Your Ref: OWPC20823
Our Ref: EP/160/18/PL 02-11-2018
Please ask for:
Mr J Baeza

Variation of condition No.3 imposed under planning reference no: EP/45/17/HH relating to the proposed materials

11 Beechlands Close East Preston

Proposed Roof Tile – Marley Modern Tile, colour smooth grey.

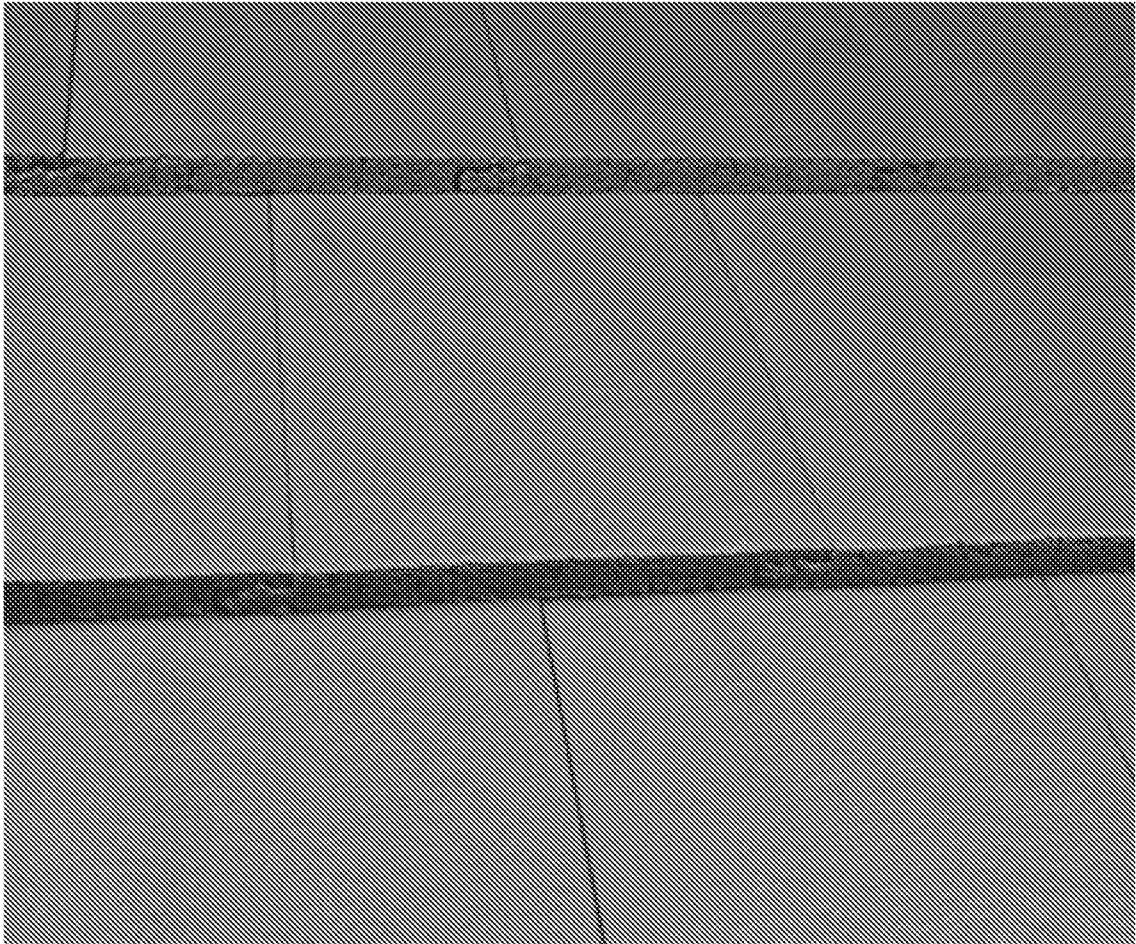
The original Approval of the extension required the 'materials and finish of the external walls and roof to match in colour and texture those of the existing building'. The roof tiles placed on this new building match neither the colour nor the texture of the existing tiles. The new building itself does not blend into the environment of the surrounding properties and the roof colour of black tiles makes it stand out even more and clashes very badly with the gentle colours of the surrounding properties. Tiles of similar colour to the surrounding properties would tend to allow this hideous property to blend a little bit into the surrounding area rather than, using the words of Prince Charles, exaggerate this dreadful carbuncle. These tiles should be replaced by tiles that match those required, quite correctly, by the original Approval.
